**KIRKLEES METROPOLITAN COUNCIL
INVESTMENT & REGENERATION SERVICE**

DELEGATED DECISION TO DETERMINE PLANNING APPLICATIONS

Reference No:	2026/62/90463/E
Site Address:	20, North Street, Heckmondwike, WF16 0AY
Description:	Erection of front and rear extensions
Recommending Officer:	Jennifer Booth

DECISION - REFUSED

PROPOSED REAR ELEVATION

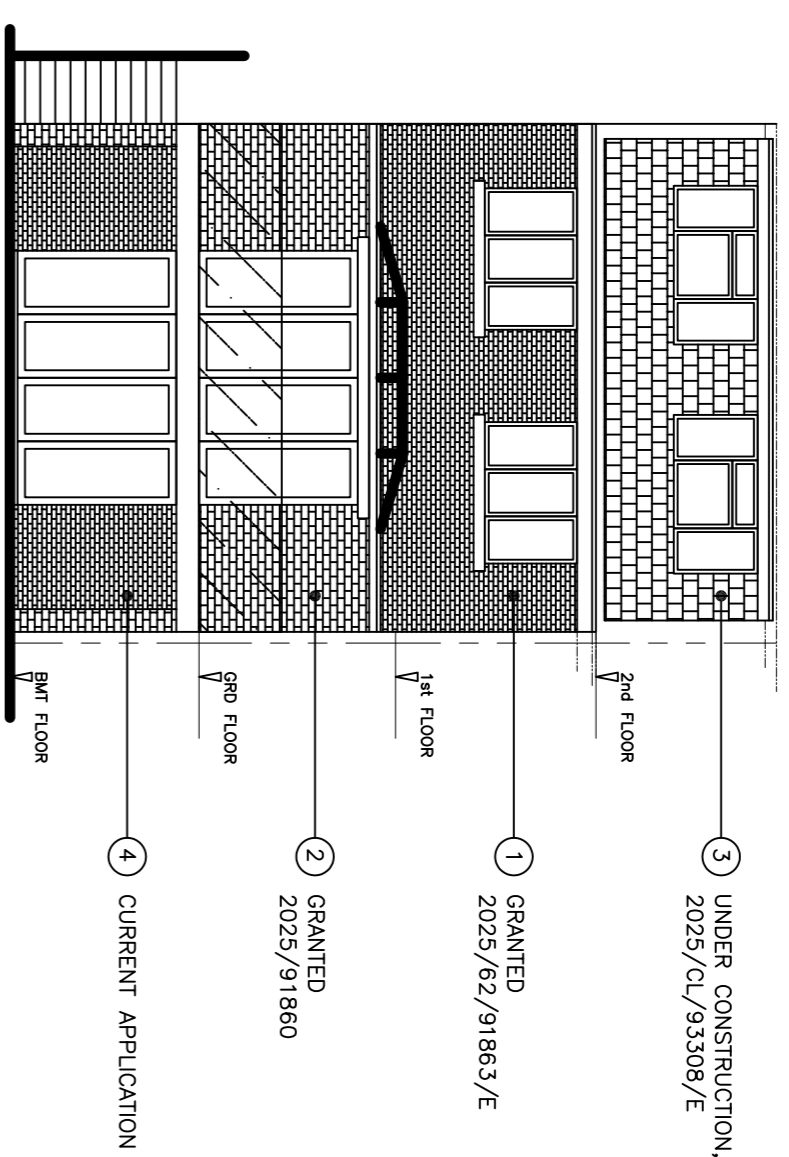
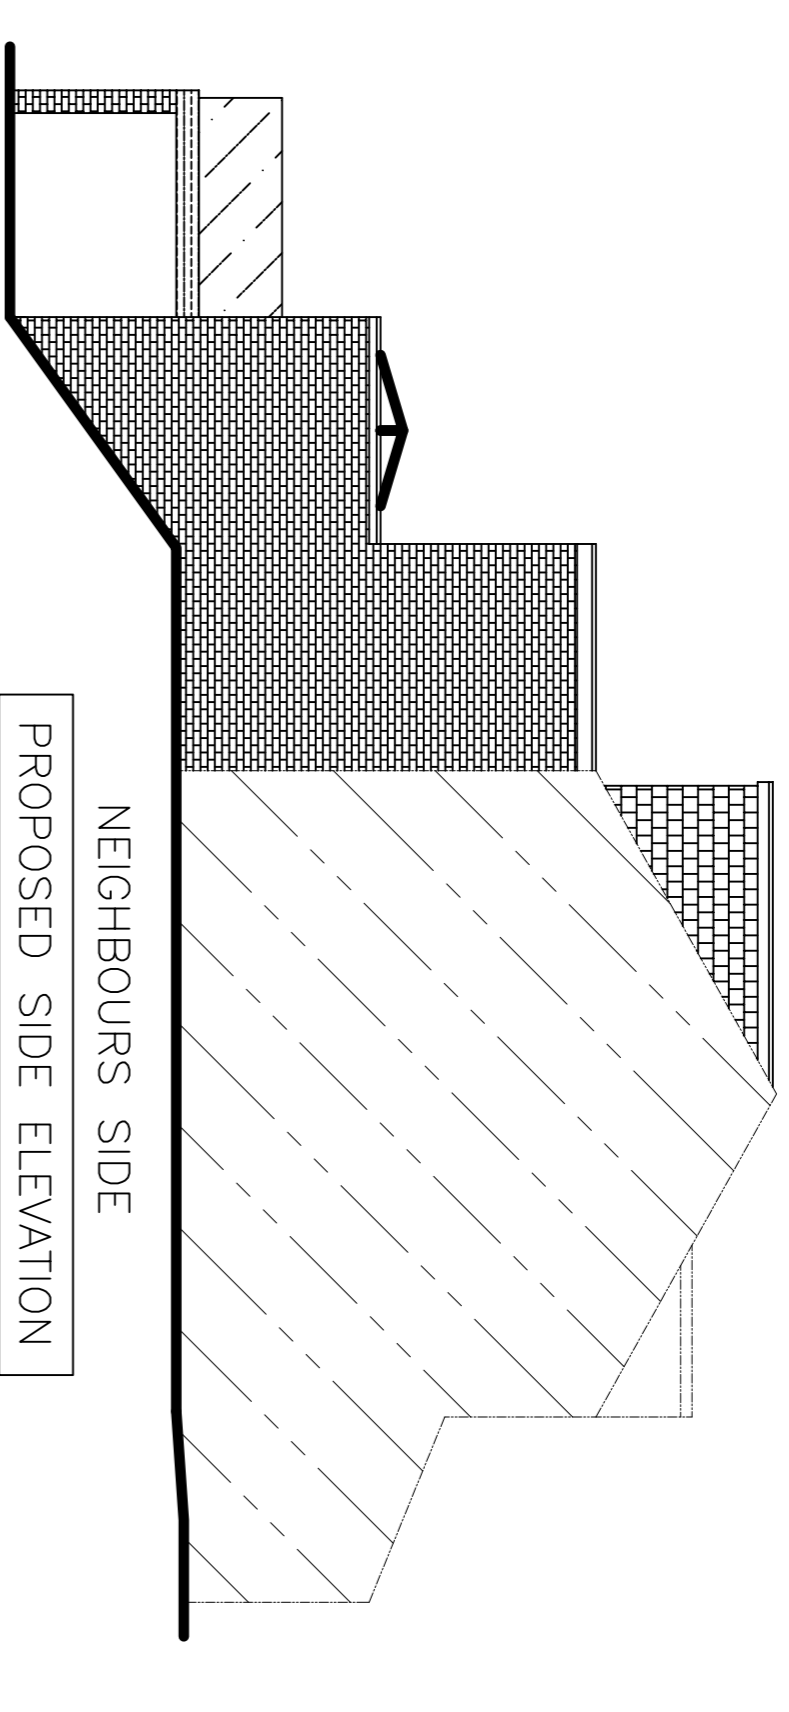
The ground floor of the rear extension has already been agreed through the larger home notification scheme. The proposed first-floor extension, by virtue of its excessive height, flat-roofed form, unsympathetic proportions, and limited regard for the established architectural character of the host dwelling, would appear as an incongruous and visually discordant addition. The increased height exacerbates its prominence, resulting in an overly dominant feature that fails to respond positively to the prevailing roofscape and vertical emphasis typical of properties in the area. As such, the development would be visible from surrounding areas and would cause harm to the visual amenity of both the host property and the wider area.

The proposed rear balcony, formed as an elevated platform on brick plinths, would introduce an additional built and visually prominent element to the rear elevation. When considered in isolation, the scale and form of the balcony may be regarded as acceptable in visual amenity terms. However, when assessed cumulatively alongside the proposed single-storey and two-storey rear extensions, the development would result in an awkward and overly complex rear arrangement. The combined bulk, layering and projecting

elements would appear visually discordant and unbalanced, to the detriment of the host dwelling's appearance, failing to achieve a coherent or well-integrated design when viewed from the rear.

The proposed rear dormer, when considered in isolation, could potentially be supported in terms of scale and visual impact. However, when assessed in conjunction with the proposed first-floor rear extension with its flat roof form, the overall design results in an awkward and disjointed arrangement. The combination of competing roof forms and massing creates a visually incongruous composition that lacks coherence and architectural harmony, resulting in poor quality design that fails to integrate successfully with the existing dwelling.

The proposed first-floor rear extension, by reason of its flat-roofed form, would appear visually incongruous and unsympathetic to the host dwelling. The flat roof fails to reflect the architectural character and roof form of the existing property, resulting in a dominant and unbalanced addition when viewed from the rear. As such, the extension would detract from the appearance of the dwelling and represents poor quality design, contrary Policy LP24 of the Kirklees Local Plan, KDP1 & KDP 2 of the House Extensions & Alterations SPD and Chapter 12 of the National Planning Policy Framework.

The proposed rear dormer, when considered in combination with the proposed first-floor rear extension with its flat roof form, would result in an awkward and incongruous composition. The cumulative impact of the competing roof forms, massing and alignment would create a visually discordant and poorly integrated rear elevation, detracting from the architectural coherence and appearance of the host dwelling. As such, the development represents poor quality design and fails to preserve the visual amenities of the property, contrary to Policy LP24 of the Kirklees Local Plan, KDP1 & KDP 2 of the House Extensions & Alterations SPD and Chapter 12 of the National Planning Policy Framework.

PROPOSED GROUND FLOOR PLAN

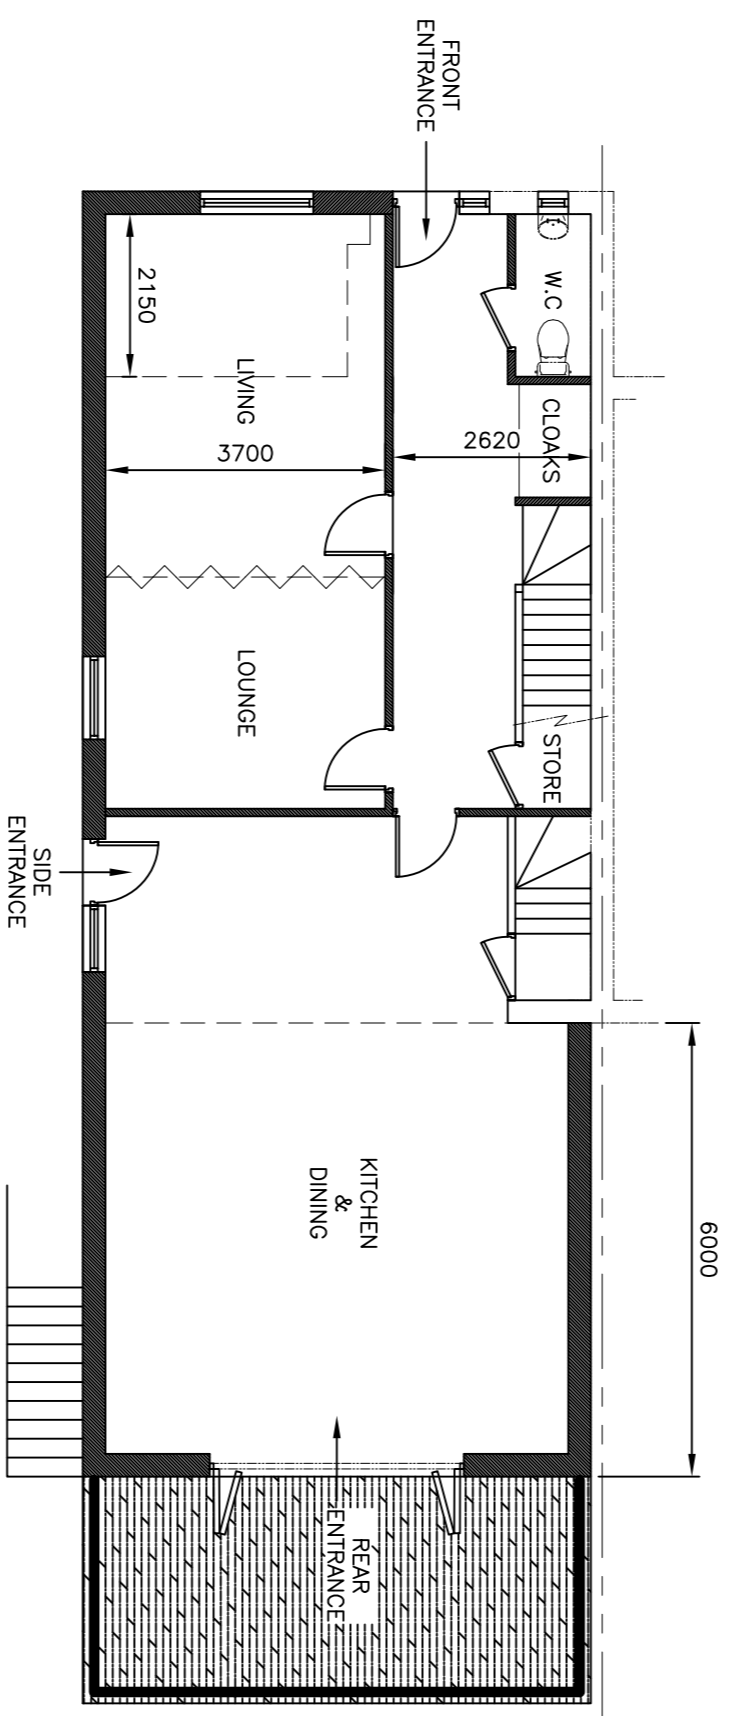
The additional platform balcony to the rear would result in overlooking of the neighbouring property. Although if minded to approve, officers could include a condition requiring screening to mitigate impact.

The proposed balcony would result in overlooking of the adjoining property as shown on plan. To provide an appropriate level of screening would result in an overbearing and overshadowing impact.

The proposal balcony would result in unacceptable overlooking of the adjoining property and cannot be sufficiently mitigated without resulting in additional overshadowing and overbearing. To permit the proposals would be contrary to Policy LP24 of the Kirklees Local Plan, KDP5 & KDP6 of the House Extensions & Alterations SPD and Chapter 12 of the National Planning Policy Framework,

PROPOSED FIRST FLOOR PLAN

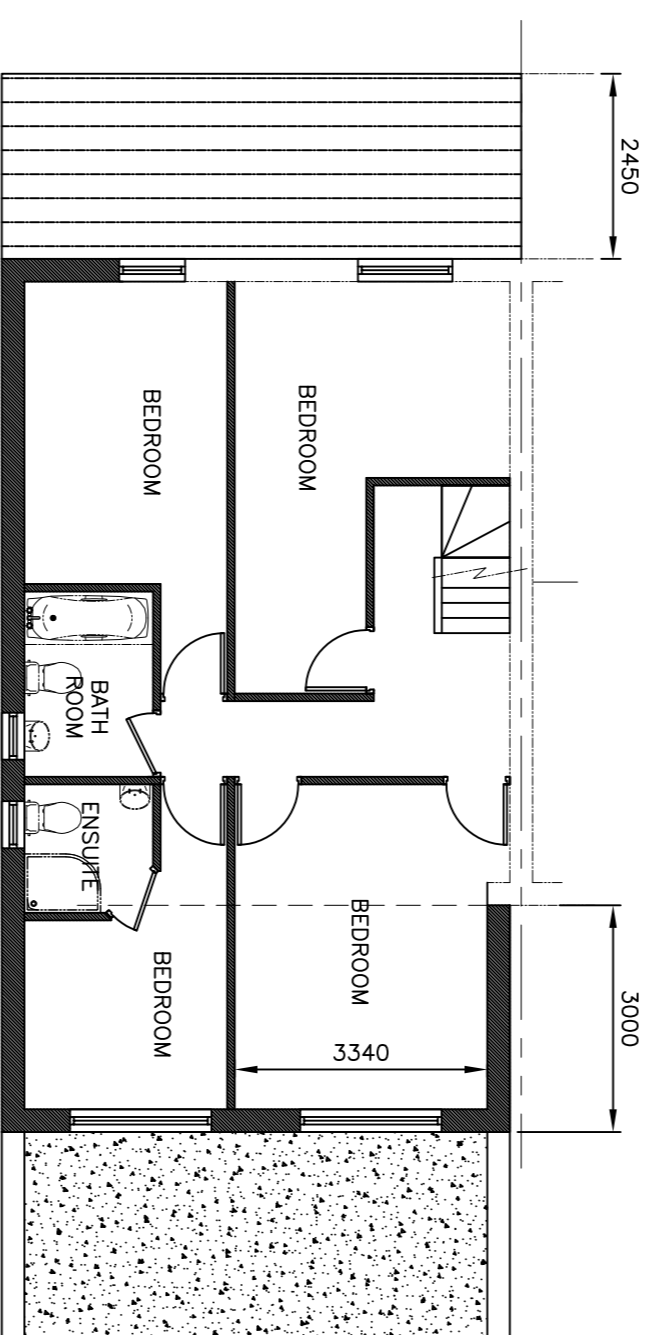
Although the rear extension would be constructed up to the shared boundary with the adjoining dwelling, the ground floor has been agreed through the larger home notification scheme. The first floor has a reduced projection and would be adjacent to the bathroom window of the adjoining property. As such, whilst there would be some overshadowing in the late afternoon and limited overbearing, this would be on a non habitable space. The windows proposed in the rear elevation would look onto the applicants own amenity space with limited potential for overlooking the neighbouring property.
